Re: MP 10\_0150 & MP 10\_0149 – Graythwaite Concept Plan

## Re- Revised EA Shore/Graythwaite

# **SHORE/GRAYTHWAITE REVISED APPLICATION.**

### **PICK UP ZONE OPTIONS REPORT DATED SEPT 2011.**

OPTION 1 NEW ENTRY DRIVEWAY OFF UNION STREET

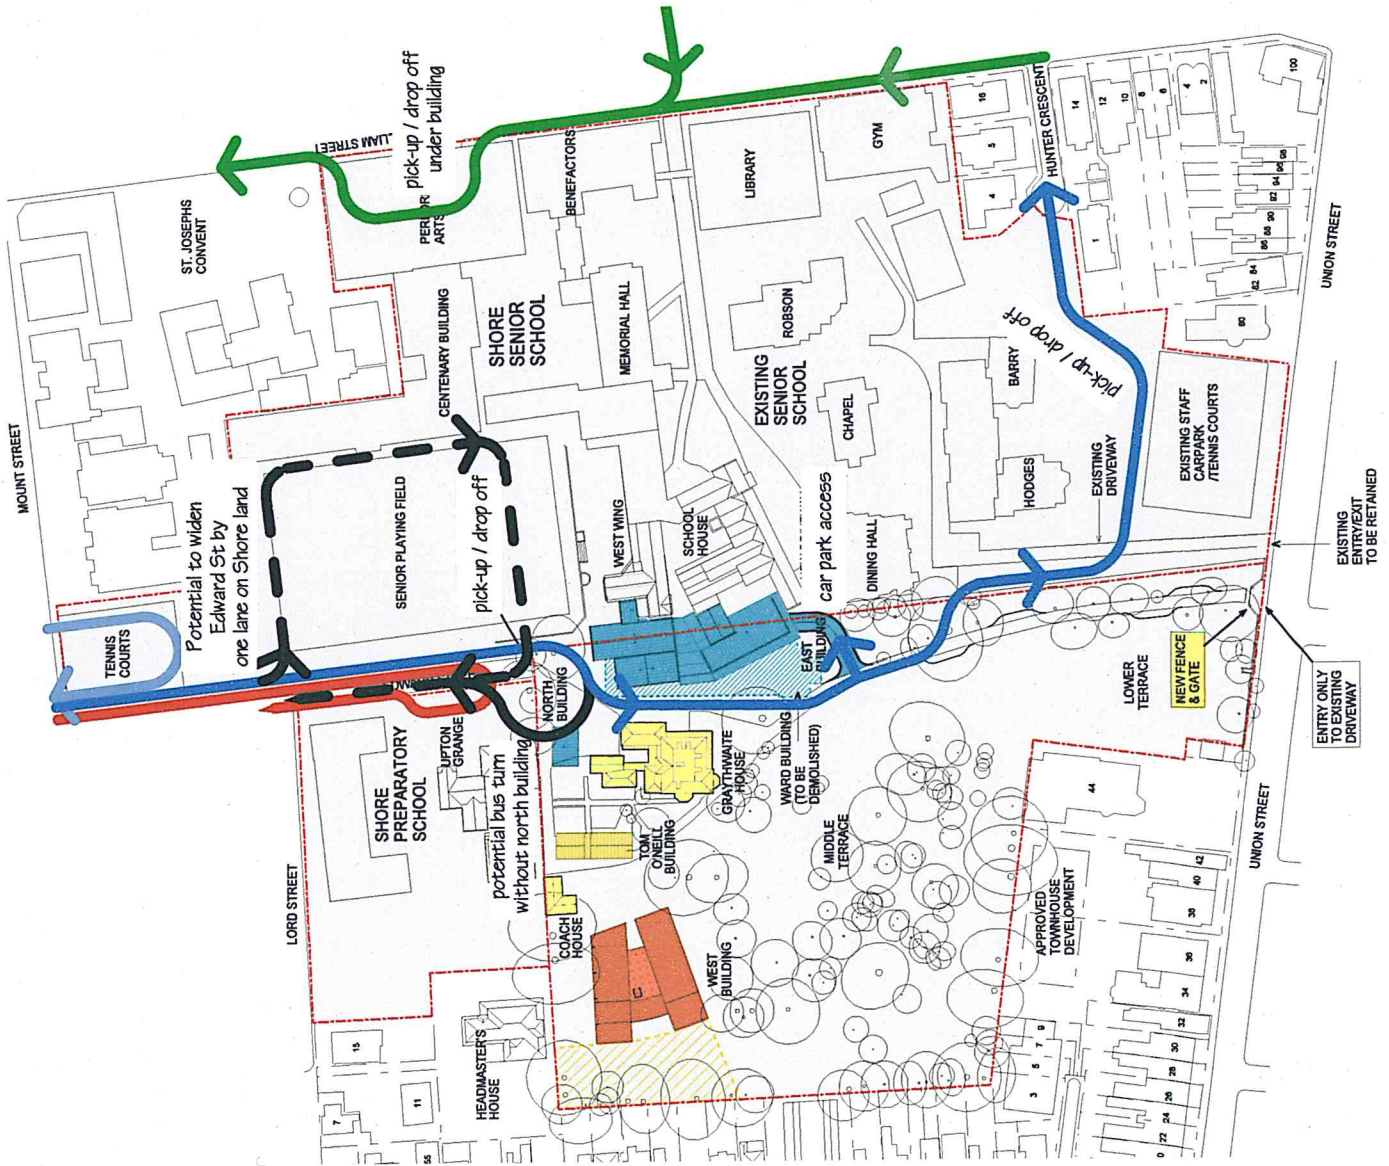
- right hand turn from Union St too dangerous
- entry is on the crest of a hill
- summer afternoon sun blocks vision
- not enough queuing space
- proponent does not own the land "requires purchasing and rezoning of land "

If Option 1 pick up was implemented with the onsite bus facility option figure 3, our daughter and many other school children who live in the area would have to cross,

- **5 double Shore driveways, measuring approx. 30 metres within a stretch of Union St of approx. 50 metres**
- 
- navigate between, exiting queued cars of Shore parents
- Shore teachers coming and going,
- mini buses and delivery vehicles,
- traffic entering and exiting Graythwaite and
- 8-12 full size coaches arriving and departing to take Shore students to Northbridge sports training
-

Camera 8 - 39 Bank St

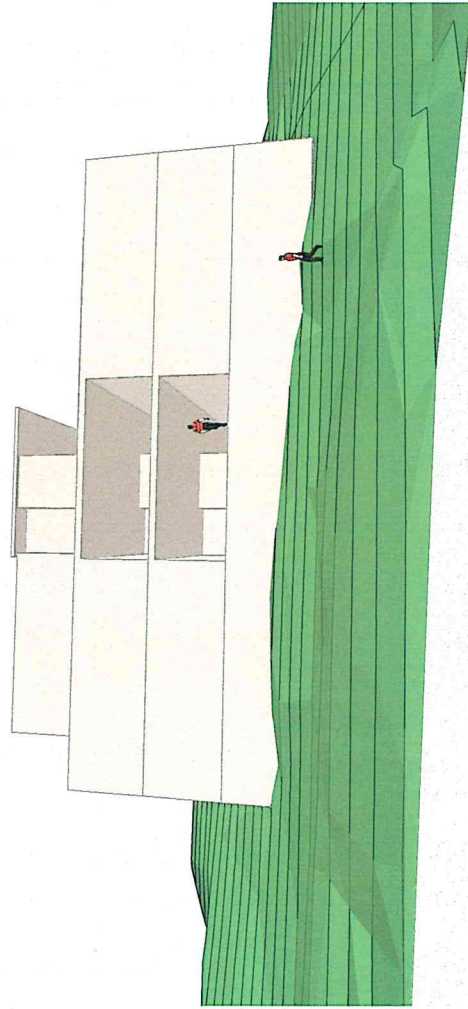
In A.502A Photo C there is a green box structure on the right hand side of the proposed building and it is not there in photo B. The same applies in A.502-B and A.503. I question the professionalism and accuracy of these photo montages and ask what is the appearing and disappearing green box?

The proposed planting that has been added to the photo montages , are these plants represented at their potential maximum size or size when planted?

Please note that even if the first elevation of the building on the western façade is 8.5 metres , the further elevations can be clearly seen even with screen planting. The height limit of 8.5 metres must be adhered to and these plans need to be refused.
